Recommendation Report for Planning Permission for Works or Extension to a Dwelling

REF NO: FG/195/17/HH

LOCATION: 59 Little Paddocks
Ferring
BN12 5NH

PROPOSAL: Demolition of existing front porch roof & rear conservatory & the erection of a part single/part two storey front & rear extension

PROPOSED PLANS

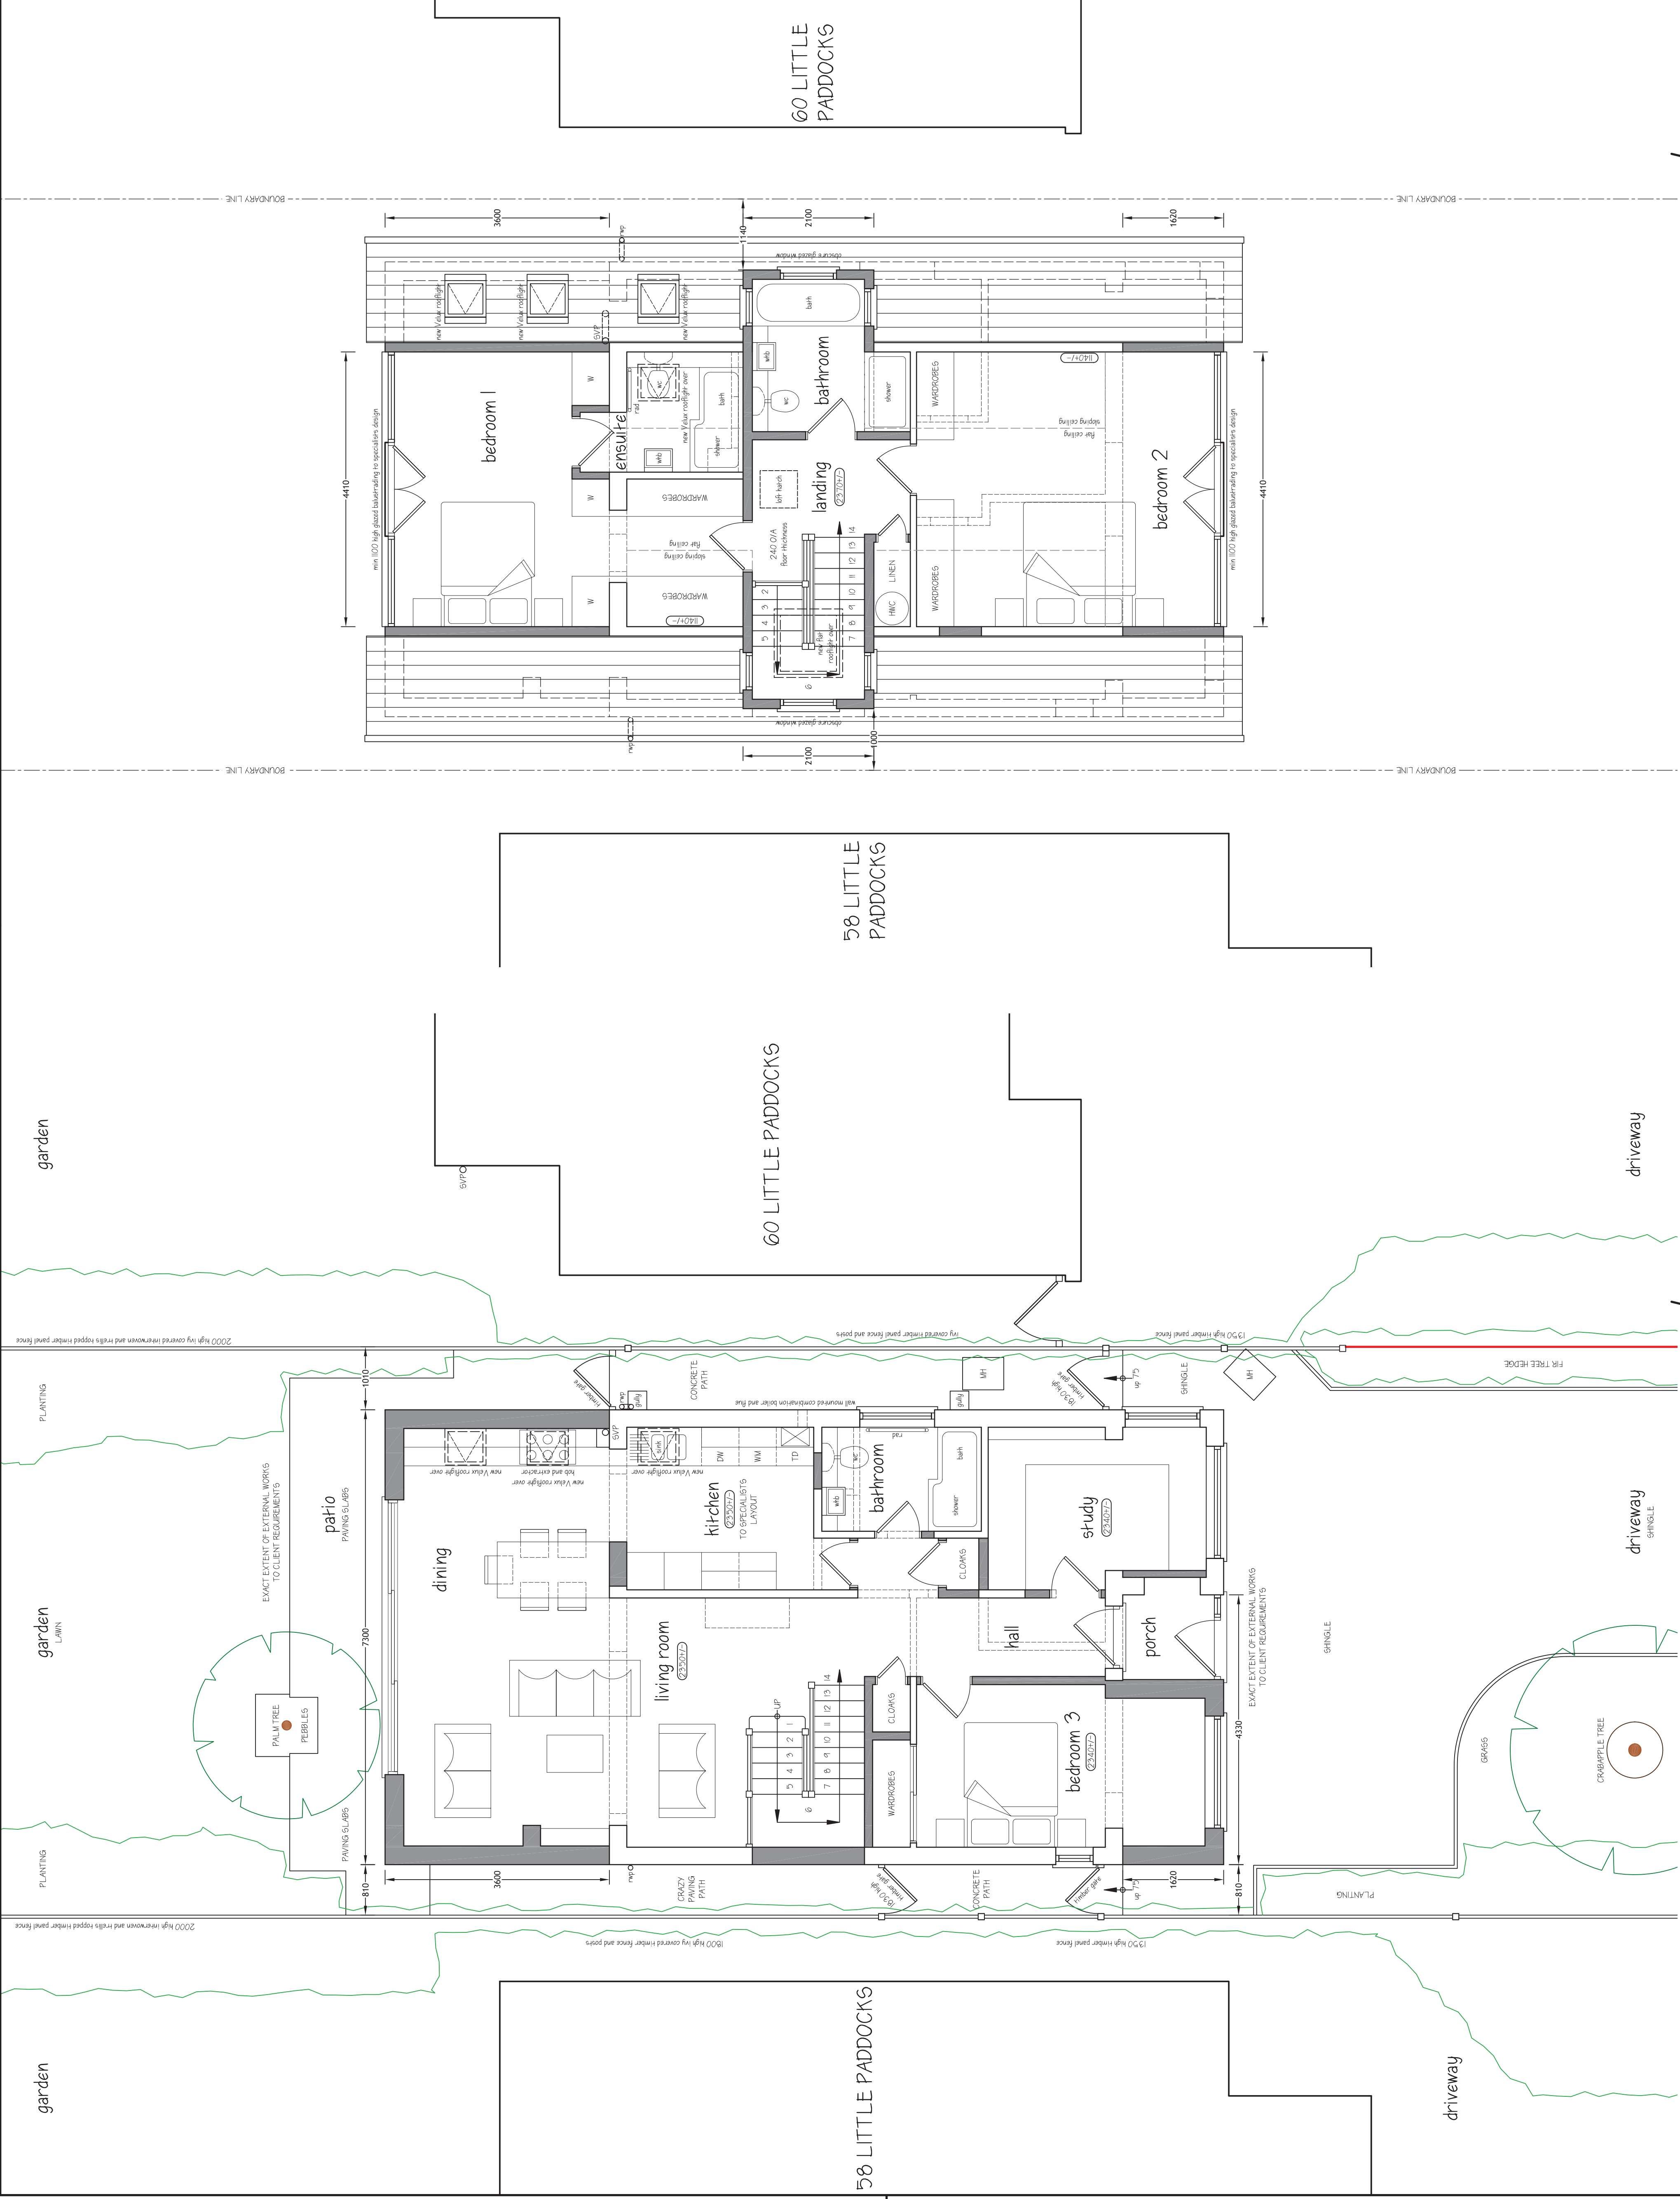
DESCRIPTION OF APPLICATION	As above. The proposal will upgrade existing accommodation at this dwelling. It will extend the dwelling slightly forwards to enlarge ground and first floor bedrooms by 1.62m. The dwelling will be extended 3.6m rearwards to enlarge bedroom 1 and also provide a dining room at ground floor. This will replace an existing conservatory. Glazed curtain walling will be introduced into the front and rear gables and side dormer would be replaced and deepened/made slightly narrower. Overall, the appearance of the dwelling would be revised to have a more post-modern appearance.
TOPOGRAPHY	Predominantly flat.
TREES	None of any significance affected by the proposed development.
BOUNDARY TREATMENT	To the front, 2m+ side hedgerows. To the rear, fencing and 2m+ hedging/planting.
SITE CHARACTERISTICS	The site is occupied by a chalet type dwelling with room(s) in roof and small single dormers on each side. Upper single window in each of front and rear gable. It is whit rendered with red small plain tile hung front gable. The dwelling has a large gravelled driveway to front which can accommodate 3 to 4 cars.

With regard to the impact upon amenity of adjoining occupiers the proposed development will introduce additional side roof lights in the west elevation, but these light the new dining room at a high level and

therefore do not result in overlooking/privacy loss. The revised side dormers will both be obscure glazed and will serve a landing and a bathroom and therefore do not result in overlooking/privacy loss. The front and rear extensions do not result in any significant level of encroachment into outlook from the front and rear of adjoining dwellings.

- 4 The windows in the main east and west facing elevations of the first floor dormers shall at all times be glazed with obscured glass and fixed to be permanently non-opening.

PROPOSED SITE PLAN AND PROPOSED ELEVATIONS

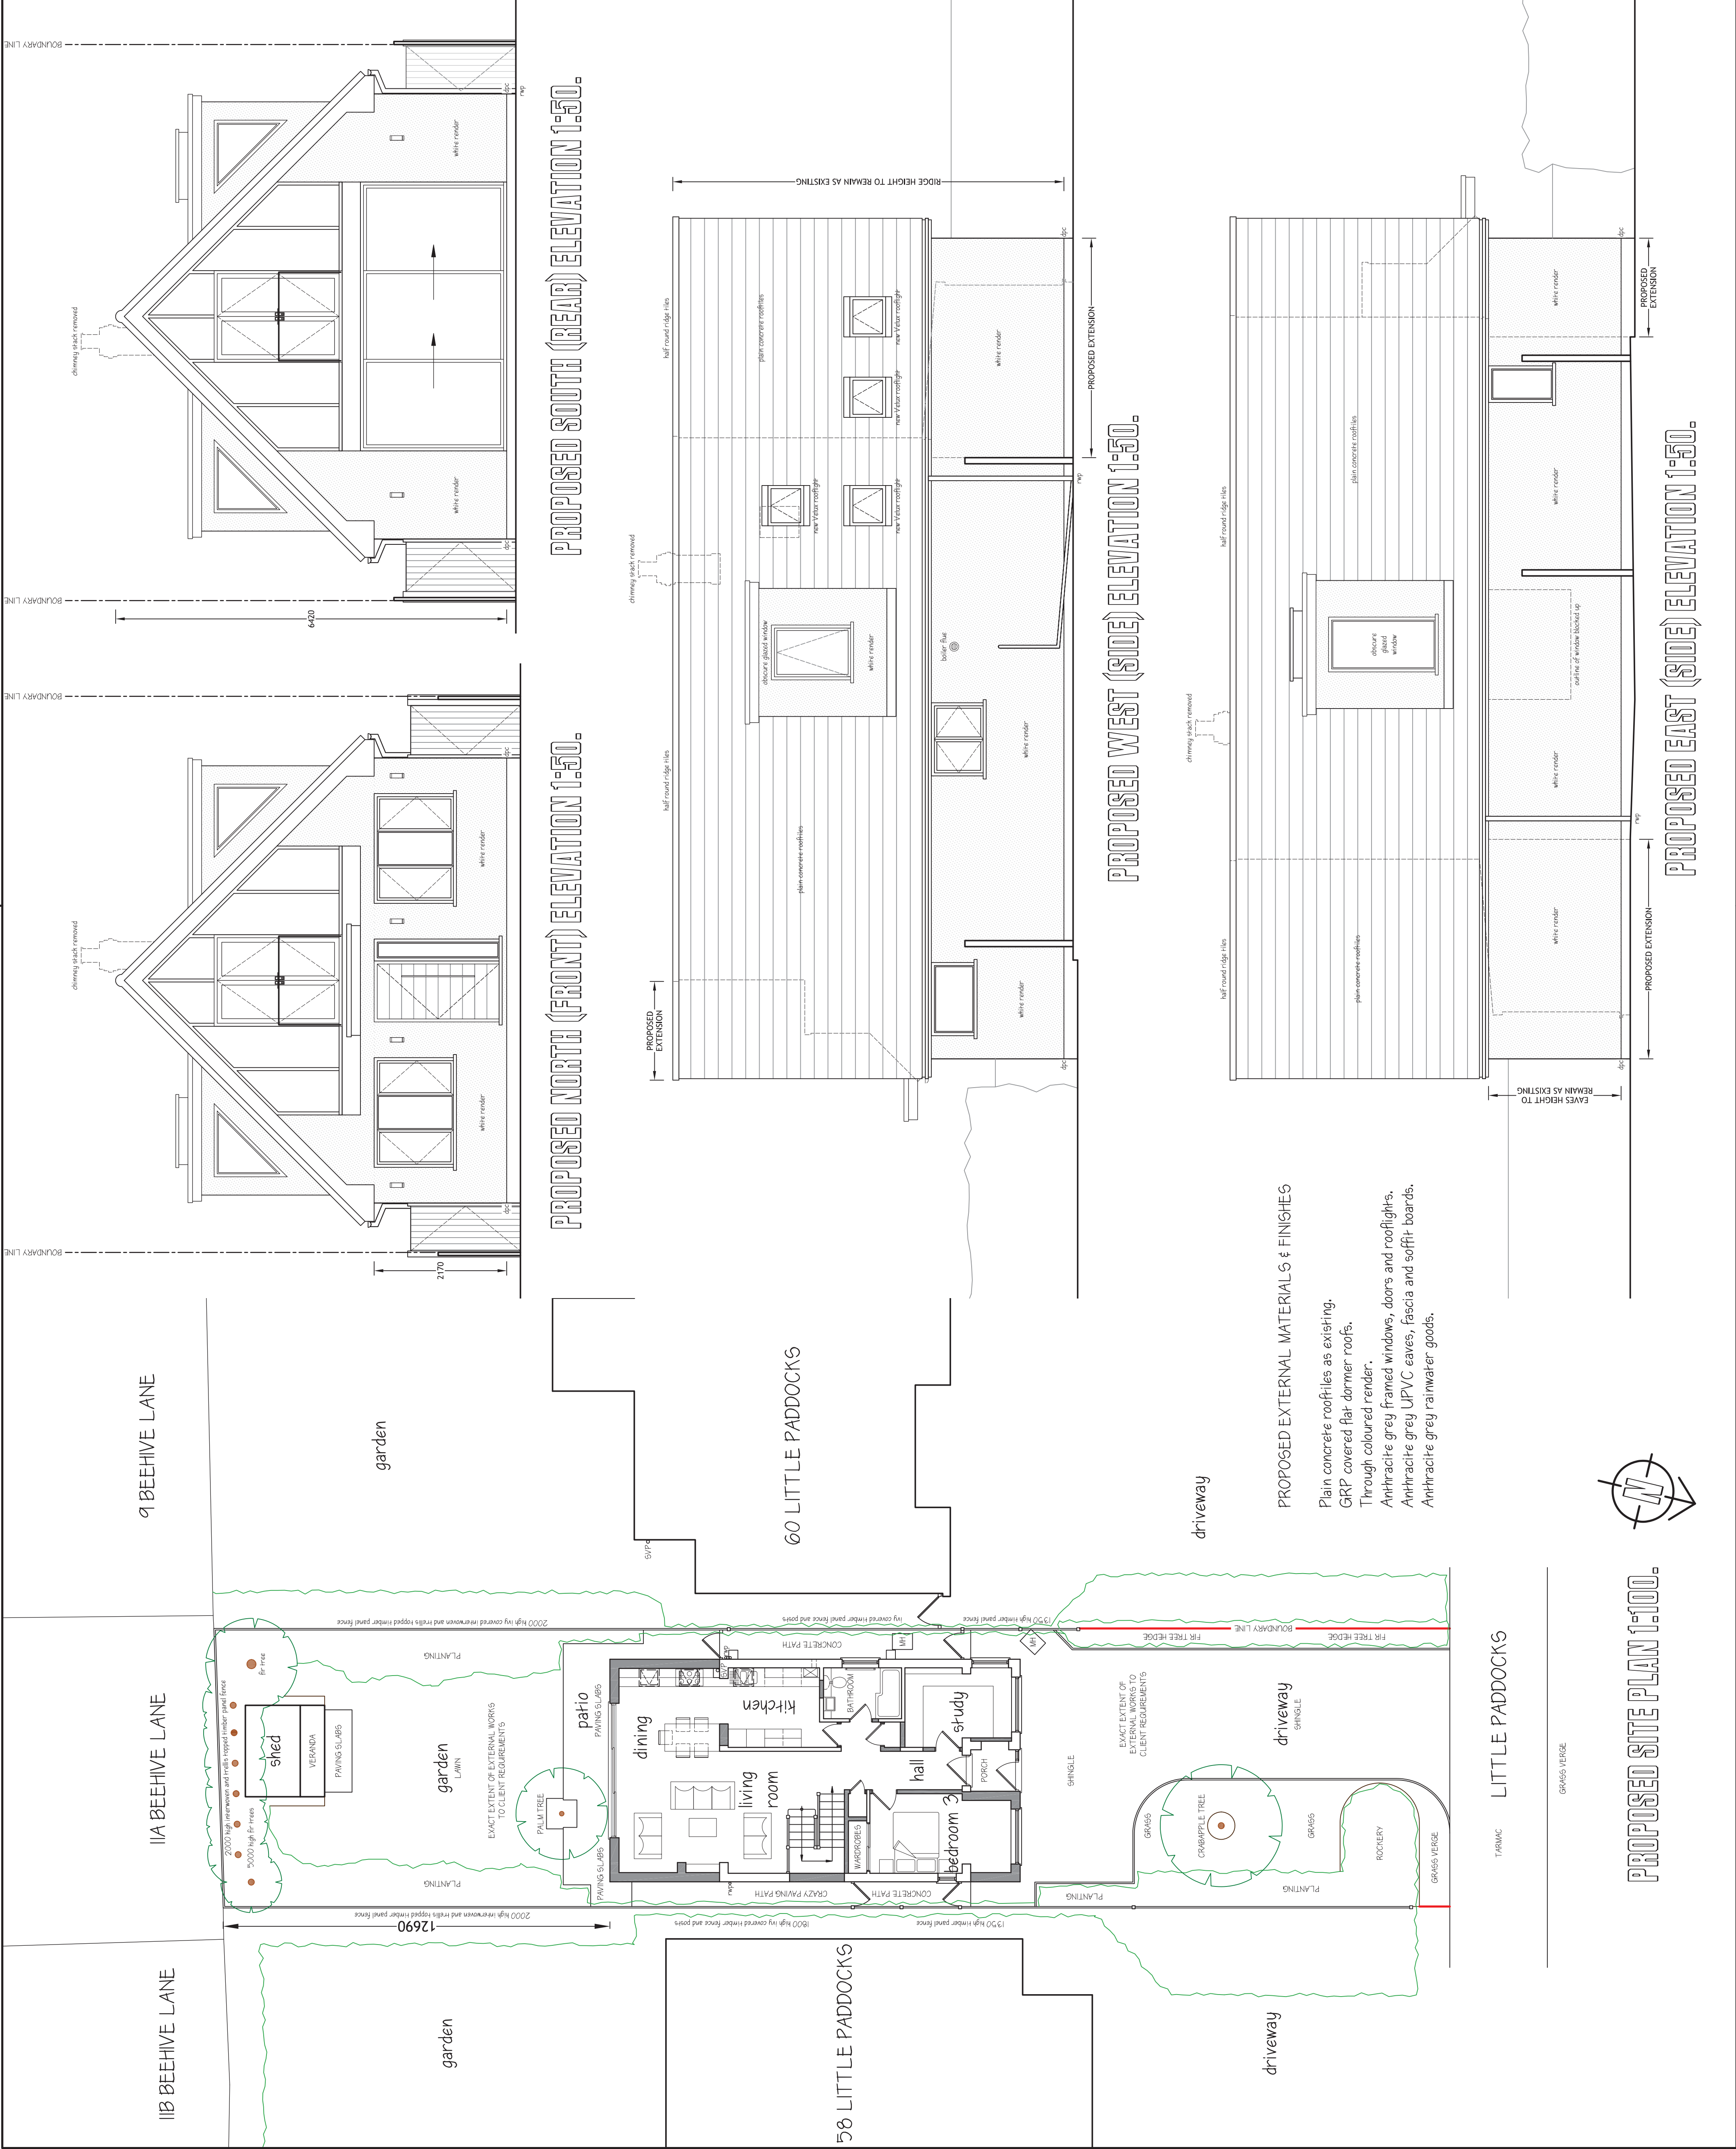
The proposal introduces a more modern and unified design into the street scene. Given the mixed character of the area, this is not considered to be intrusive or incongruous and therefore not considered to result in unacceptable harm to visual amenity. The scale of the proposal is not excessive and the massing and appearance of the dwelling has not unduly changed. The scheme which will not be unduly dominant or intrusive visually in terms of impact on surrounding dwellings.
